**North Carolina Department of Health and Human Services**  
**Division of Public Health**

August 3, 2020

RE: Tropical Smoothie Cafe  
1546 NC Hwy 24/87  
Cameron, NC 28326

This letter acknowledges review of the plan for the above remodel of the referenced establishment. The original plan dated 03/05/2020 and specifications are approved with the following comments:

5 DINING WALL ELEVATION
A4.1

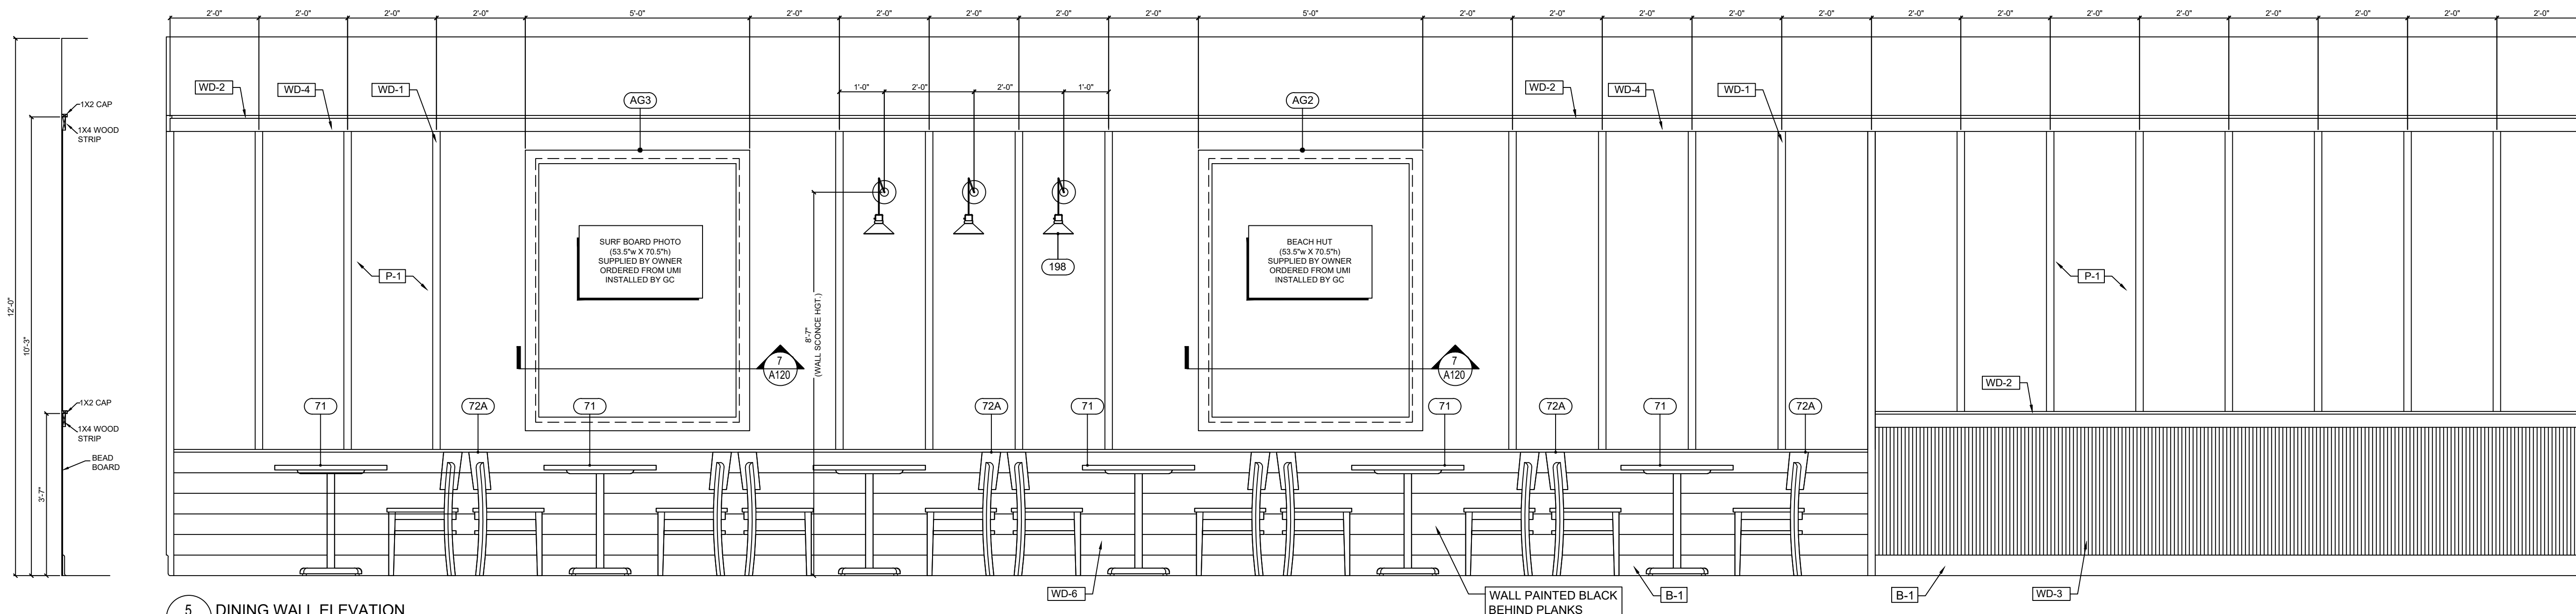
2. Splash guards will need to be installed where there is a concern for sink splash to prevent potential contamination.  
Sneeze guards will be installed as shown on elevation plan sheets 4.0 and 4.1, and on the Equipment Plan sheet A5.0.  
A covered waste receptacle will need to be provided for the disposal of sanitary napkins to meet NC Food Code requirements.

1 WATER PIPING PLAN
1/4" = 1'-0"

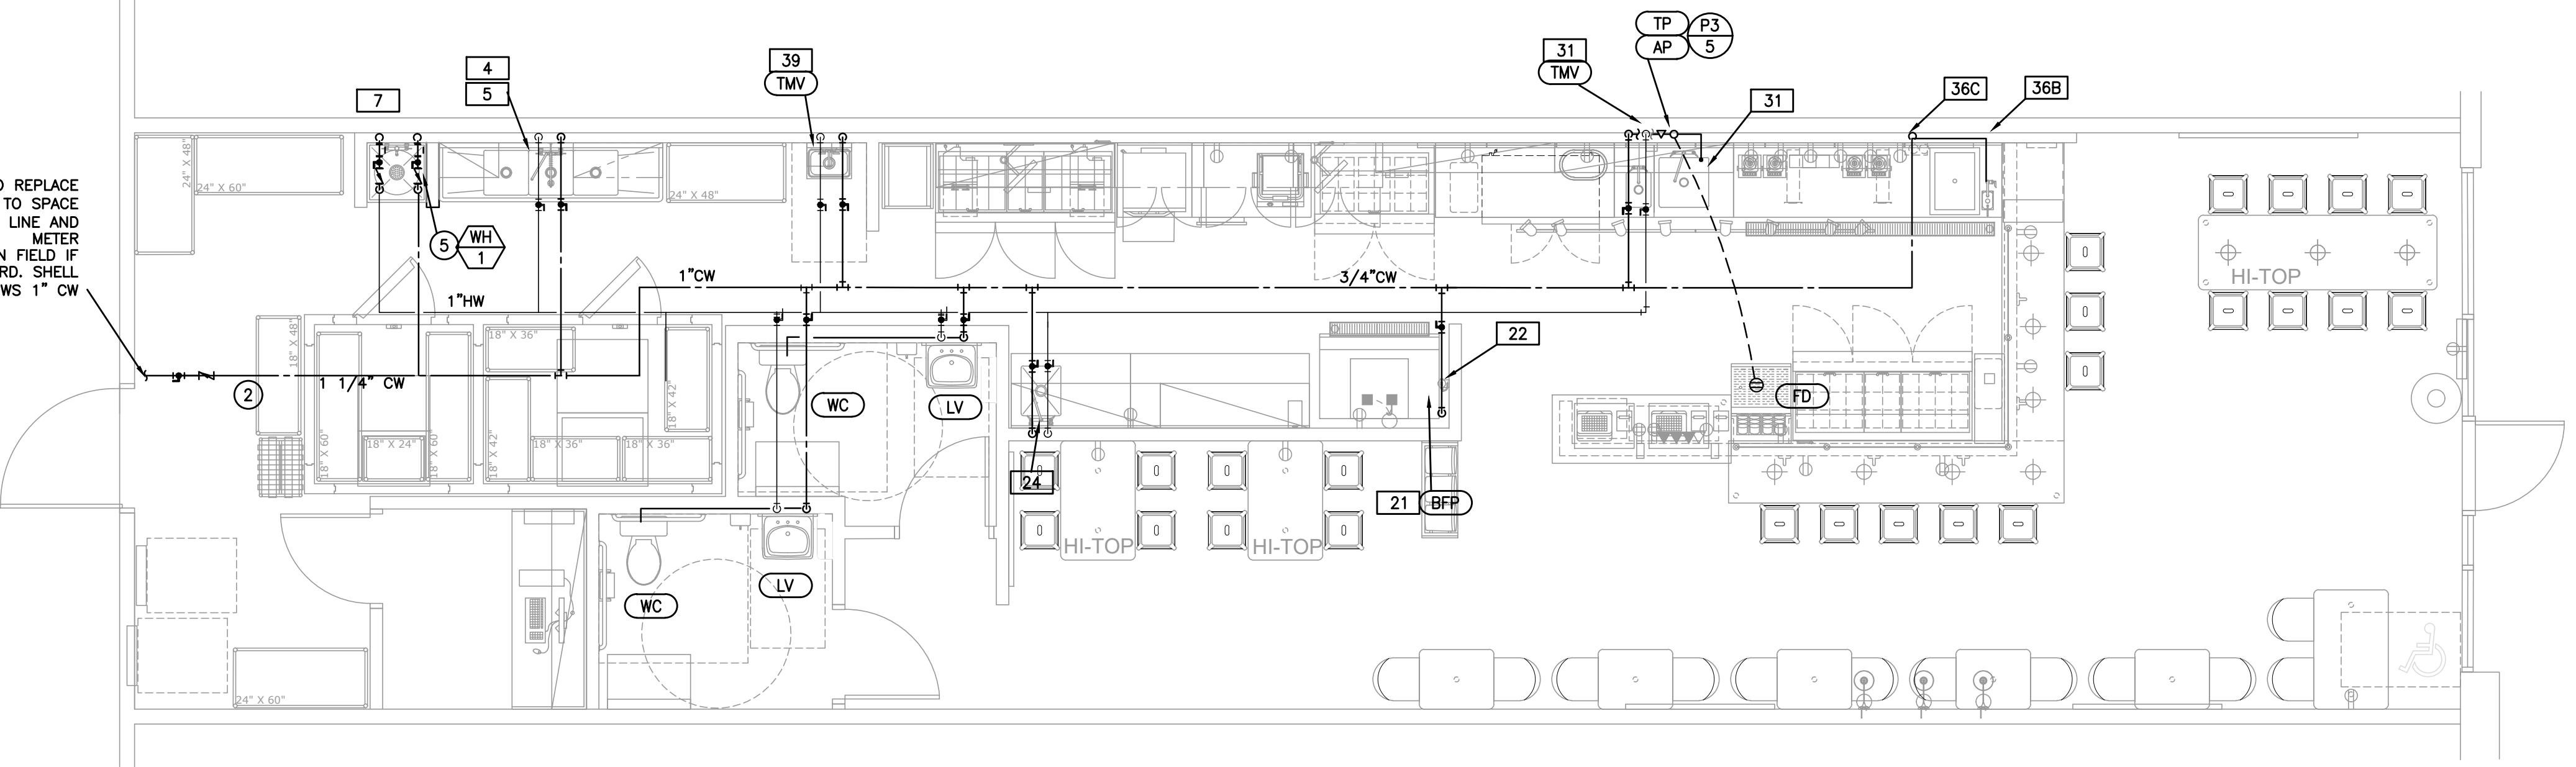
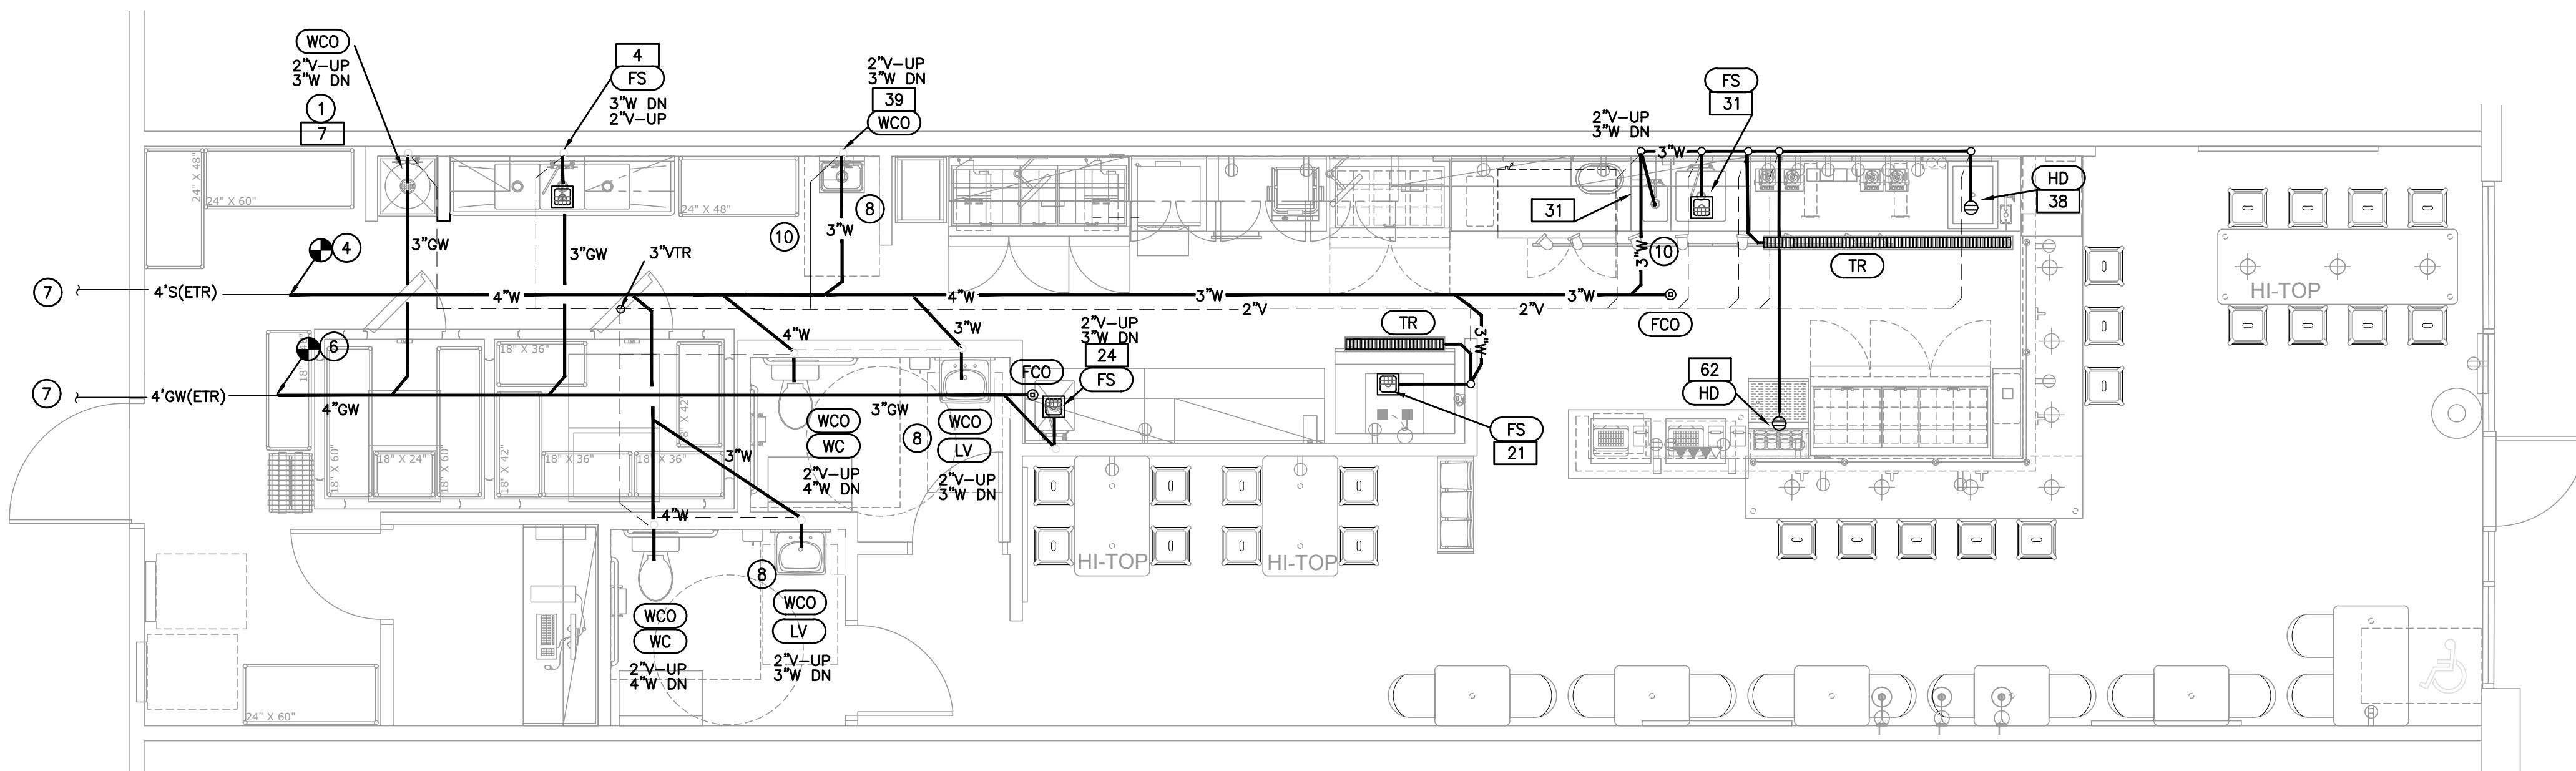
2. The plumbing waste and water plans on sheets P1 and P2 are approved, as is the installation of a new, revised 50Gallon, 18KW, 3 phase heater which is changed from what was noted in the application and in the original Plumbing Schedules on plan sheet P1.0. A revised P1 sheet reflects the up-sizing of the proposed electric water heater to meet hot water recovery requirements.
